Application by Drax Power Limited for an Order Granting Development Consent for the Drax Bioenergy with Carbon Capture and Storage Project

Request for further information

Questions under EPR Rule 17 (R17QA)

Issued on 6 June 2023

Plate 1.2 - Modelled Buildings Layout

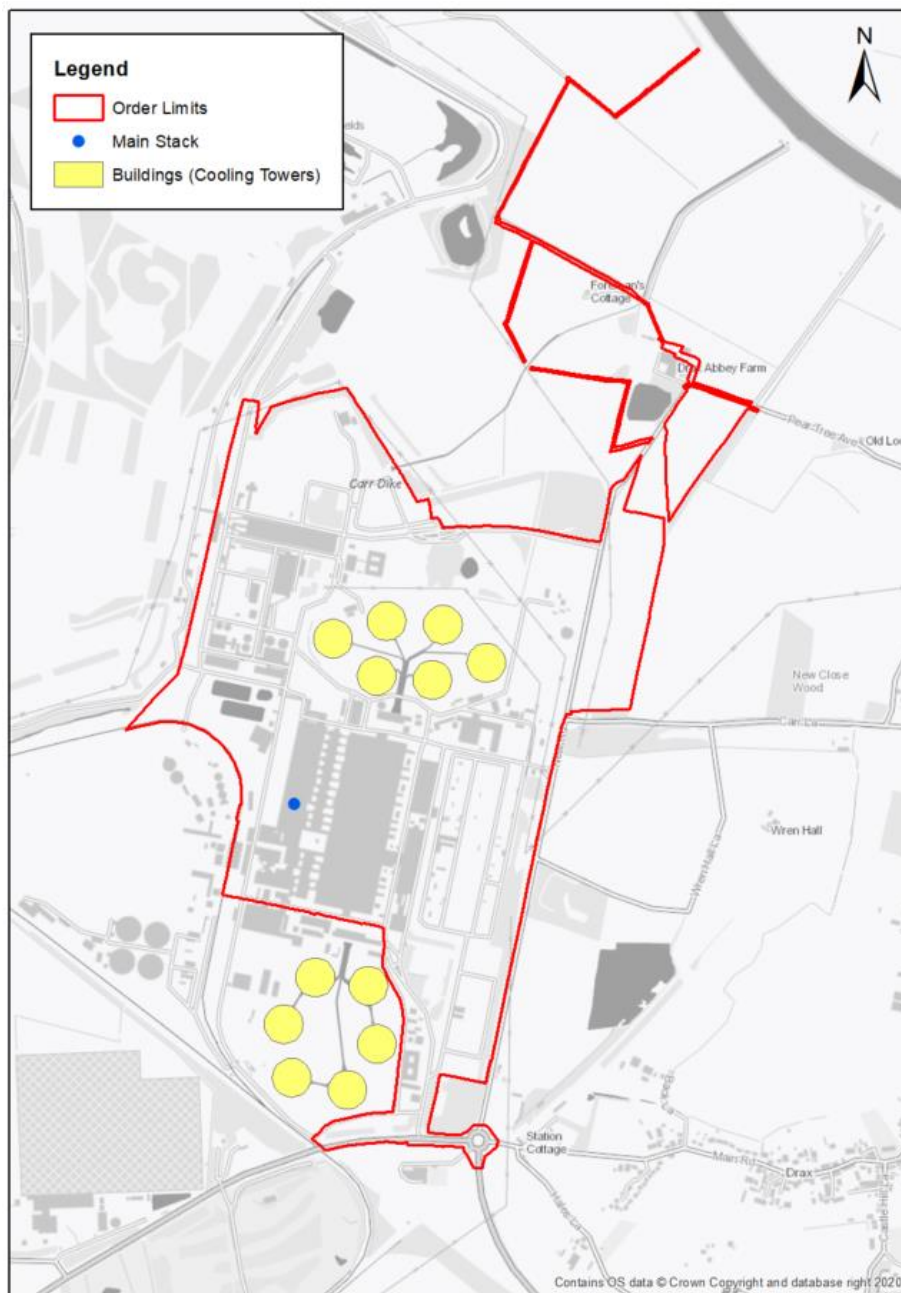
R17QA.10	Applicant	<p>The ExA notes that the Applicant explains in [REP4-020] that the modelling for the mid-merit operational scenario explicitly includes partial operations when only the BECCS units are operating. Biofuelwatch in its D6 submission [REP6-034] reiterates its concern that aldehyde and nitrosamine concentrations from the BECCS units would increase at times that the non-BECCS units are not operating.</p> <p>i. Can the Applicant explain how, within the mid-merit scenario, the short-term concentrations of amines, nitrosamines and aldehydes differs between the times when only the BECCS units are operating and when the non-BECCS units are also operating?</p> <p>ii. Can the Applicant direct the ExA to where the increased short-term impacts when only BECCS units are operating are captured within the Applicant's assessment?</p>
R17QA.11	Applicant	<p>The ExA notes the Applicant's response ref. 5.17 in Responses to Issues Raised at Deadline 6 [REP7-017] that it has never been asked to assess unmerged plumes. However, the Applicant is asked to clarify whether the emissions from the BECCS unit flues will behave differently from the emissions from the non-BECCS units,</p>

R17QA	Question to:	Question:
		due to different flow rate and temperature, impacting how well the plumes merge? And if so, would this change the results of the assessment?
R17QA.12	Applicant	<p>The ExA notes that the Applicant confirmed in Responses to Issues Raised at Deadline 6 [REP7-017] (response ref. 5.14) that the annual average impacts will not be perceptibly impacted by calm conditions. The applicant is asked:</p> <ol style="list-style-type: none"> i. Whether its approach to the dealing with calm conditions in the air quality modelling has been agreed with the EA? ii. Whether including 0.7% of hours in the year as calm conditions would change any outcomes of the air quality assessment, and if so, how?
R17QA.13	EA	<p>In its Written Representation [REP2-073] (paragraph 122) and again in its D6 submission [REP6-034], Biofuelwatch raised three questions relating to the regulation of amine emission rates, emissions temperatures and flow velocity. Could the EA provide a response to Biofuelwatch’s questions as follows:</p> <p><i>“Biofuelwatch requests that the Examining Authority asks the Environment Agency to:</i></p> <ol style="list-style-type: none"> a) <i>Confirm that it will regulate emissions to ensure that amine emissions rates will be no worse than assumed by the applicant in the application (including after taking measurement uncertainties into account - see previous subsection)</i> b) <i>Confirm that it will regulate the emissions temperature to ensure that the temperature will be no less than modelled by the applicant (because the temperature will impact buoyancy and dispersion)</i> c) <i>Confirm that it will regulate flow velocity to ensure that the velocity can be no less than modelled by the applicant (because the velocity will impact dispersion)”.</i>
